Re: EP/37/20/HH 56, Angmering Lane, East Preston BN16 2 TA.

I strongly object to the above development.

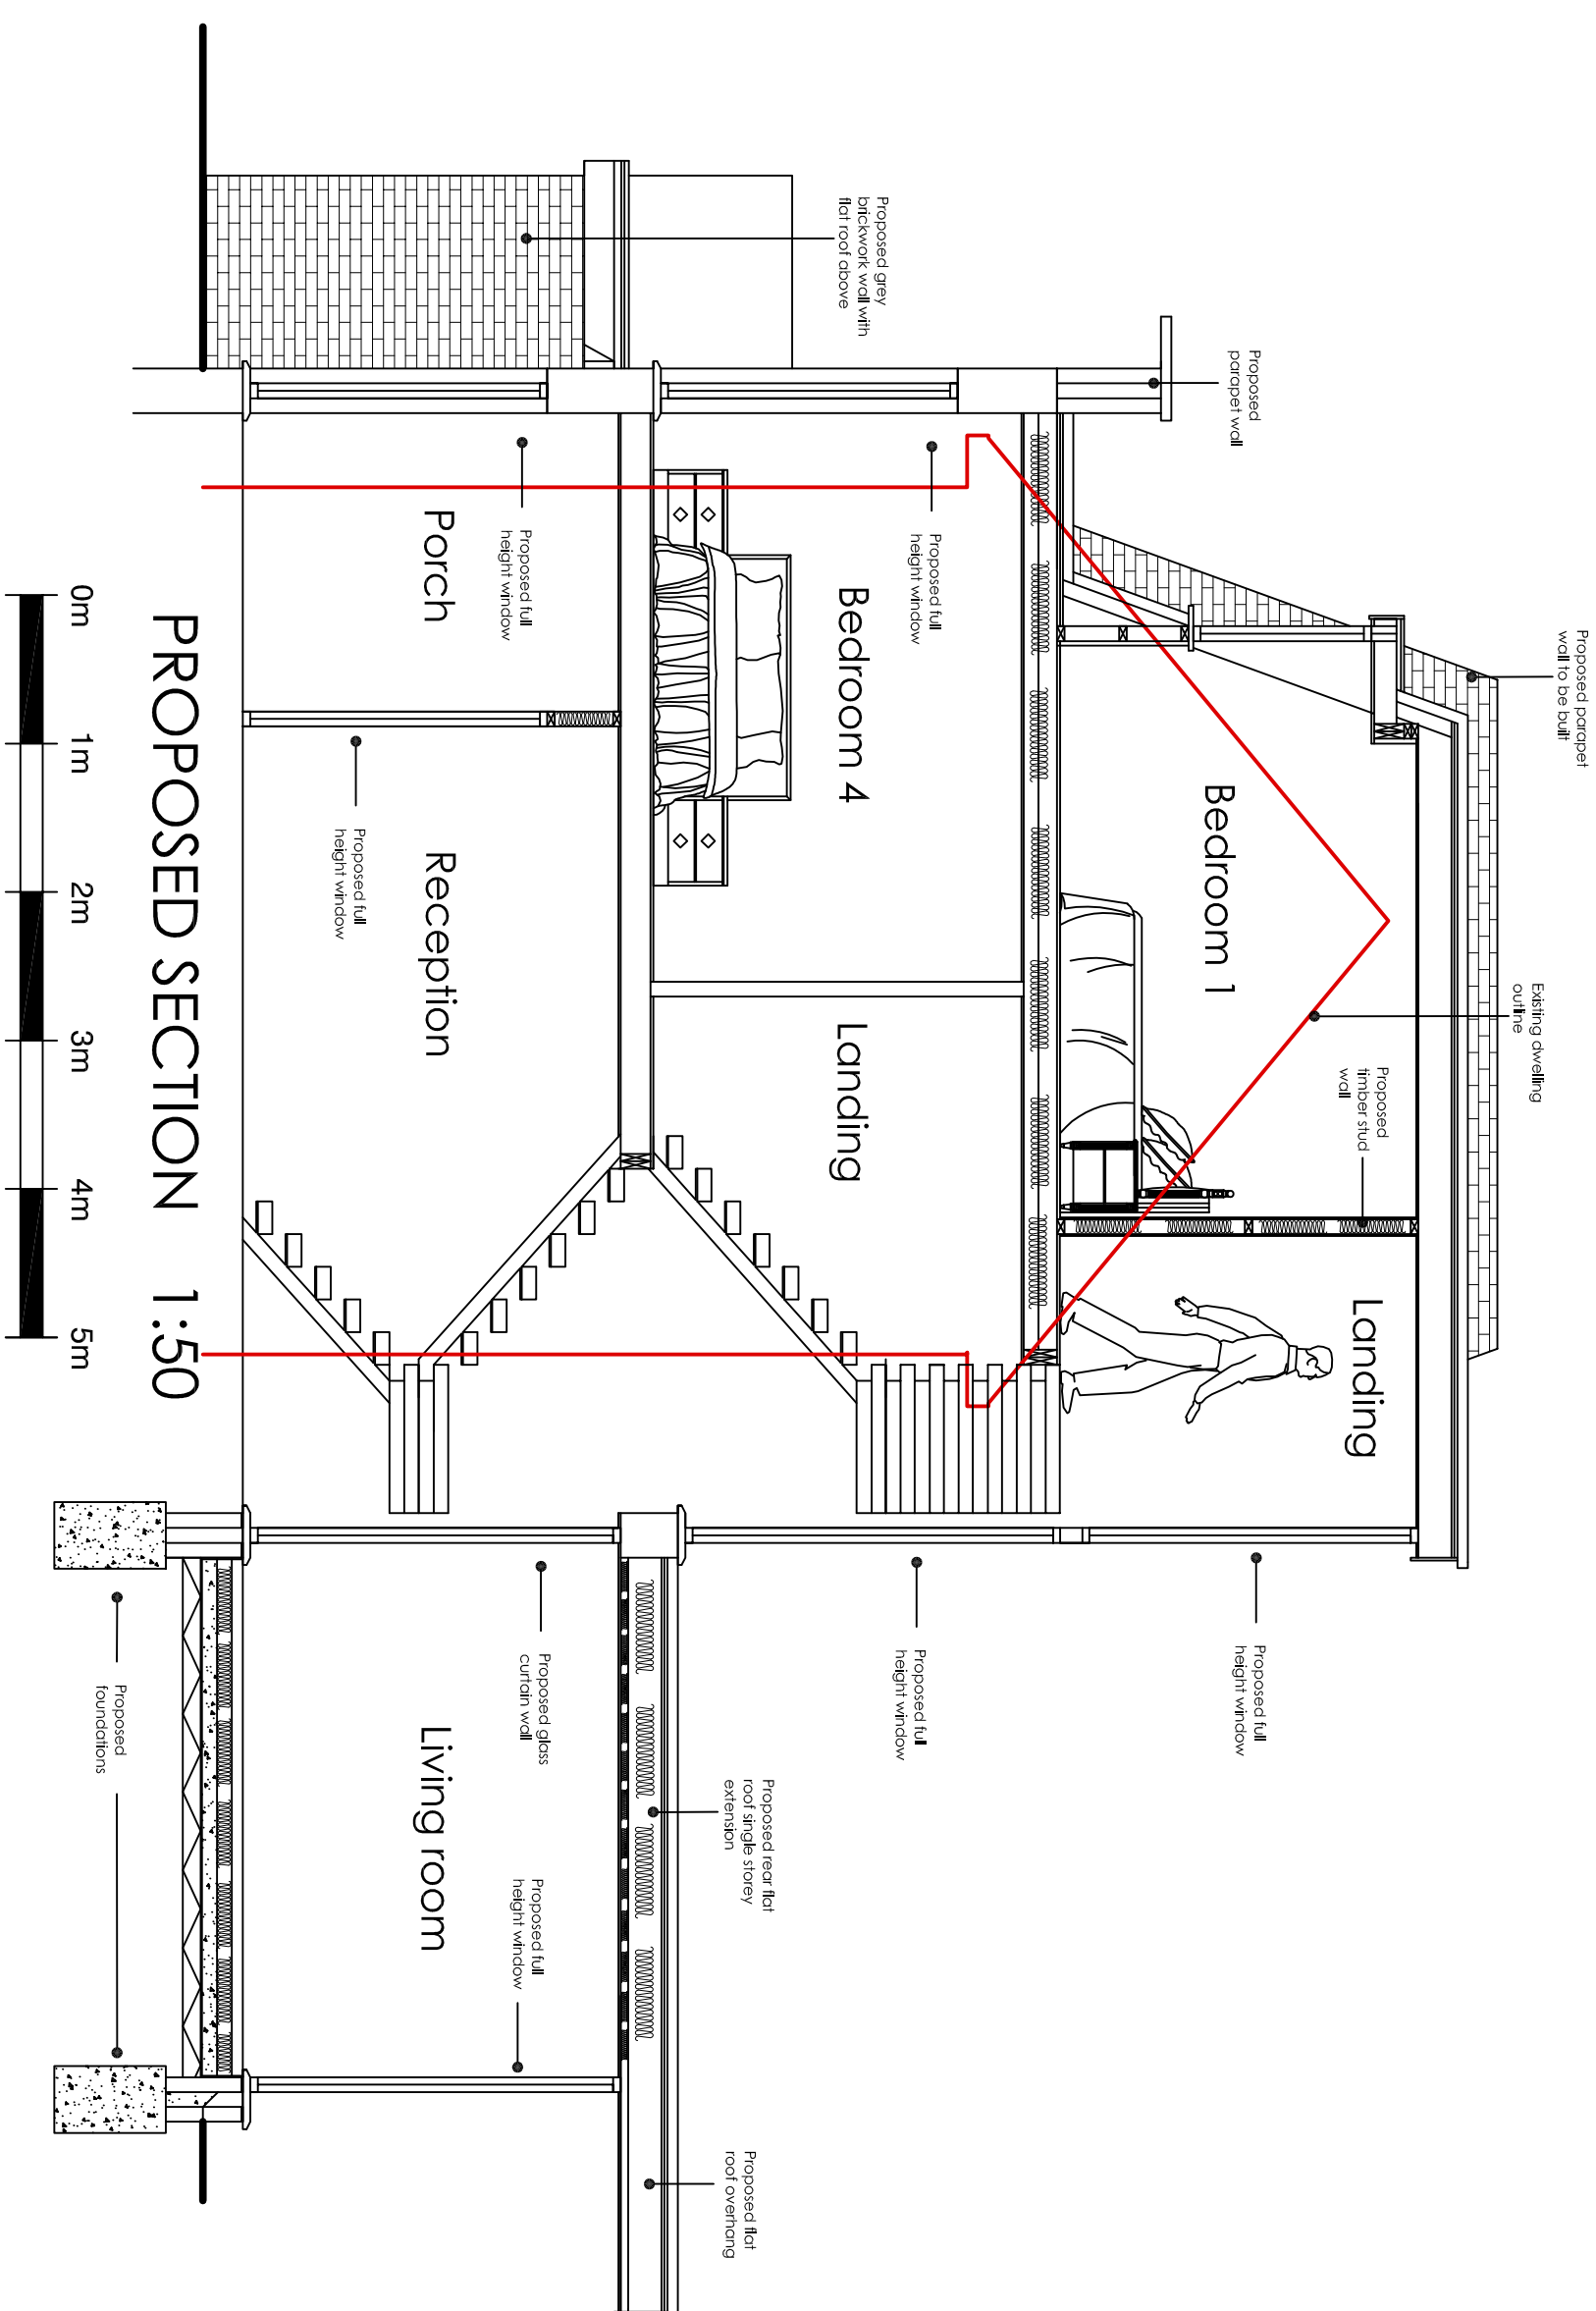
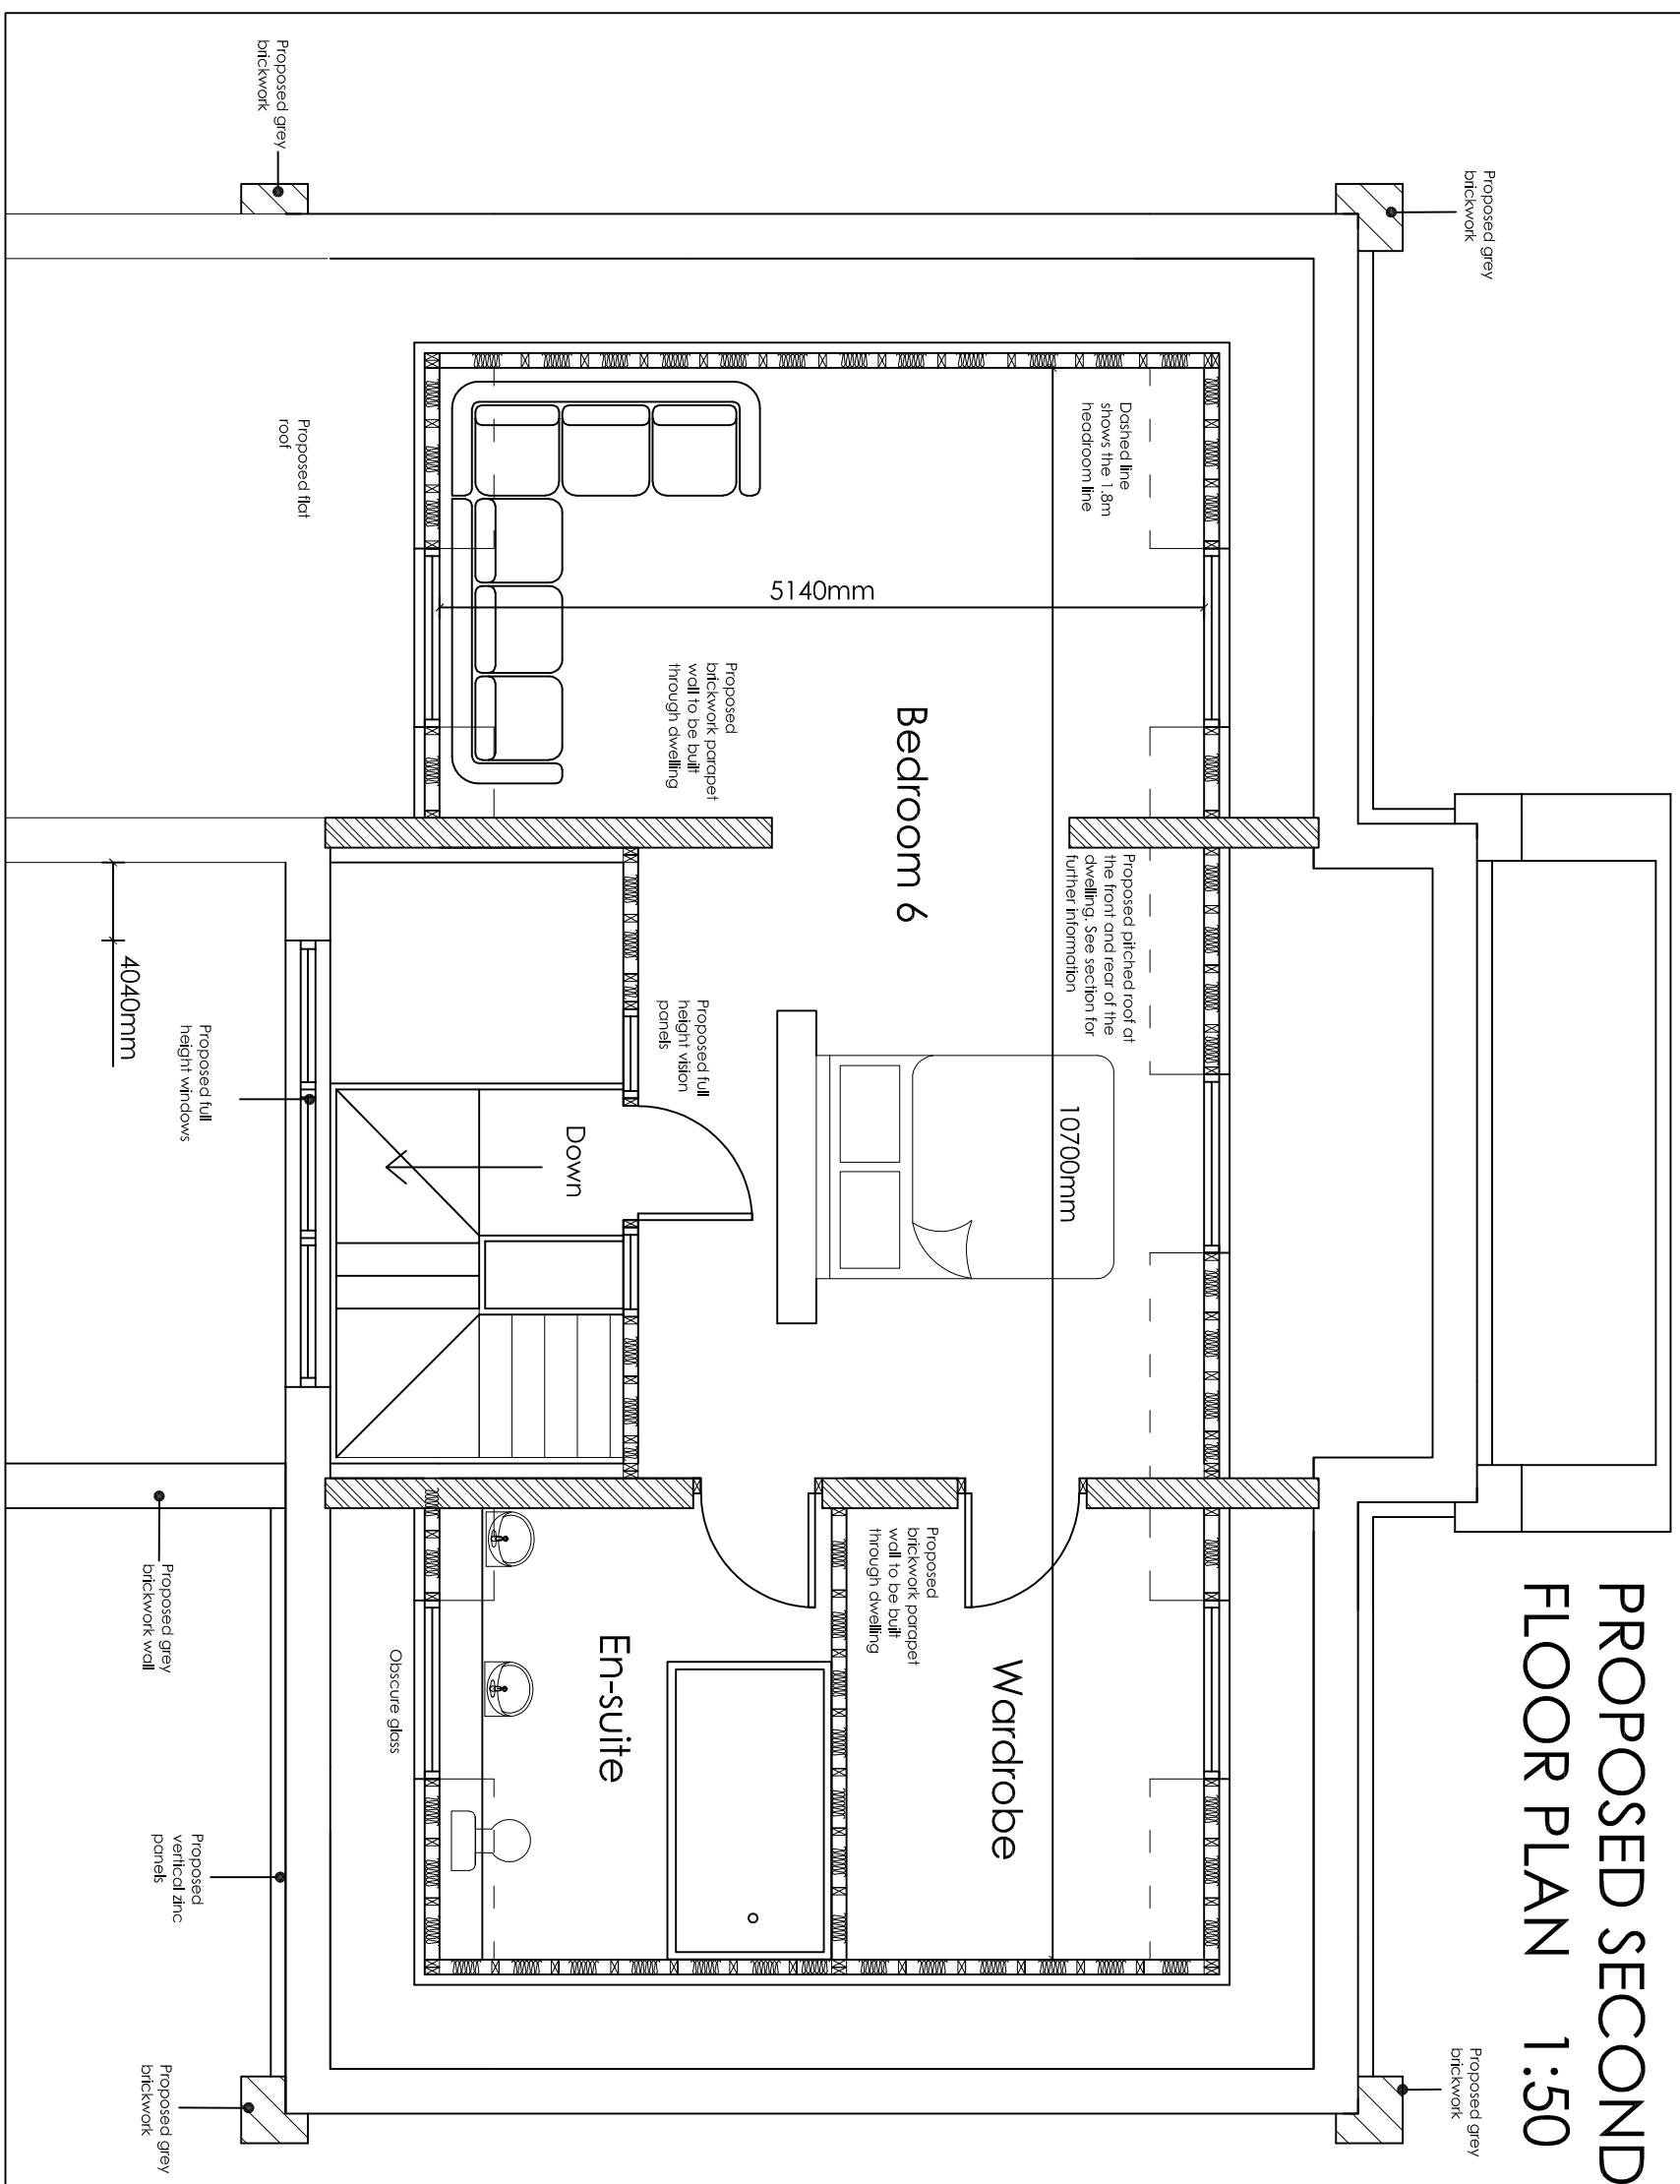
The addition of a third storey with large windows will mean the development will be so high it will be an invasion of my privacy. No other properties on the Willowhayne have a third storey. Because the construction involves a large amount of glass, the finished building will resemble a block of flats. The Neighbourhood Plan, Policy 1: Housing – General Principles states (page 20):

My next objection relates to the materials that are to be used, specifically the application of zinc cladding. Zinc cladding is more appropriate for an industrial estate not a private estate and again there are no other properties on the Willowhayne that are built using this material. Since there are a variety of finishes to zinc cladding, I am concerned about the reflective nature of what might be used. The Neighbourhood Plan has clear directives relating to building materials:

The proposed development shows a new garage located at the front of the property. This garage would project beyond the building line. Properties on the Willowhayne all have covenants that restrict anything being built in front of the building line. If the garage was to be built at its planned location it would be in breach of this covenant and therefore unlawful.
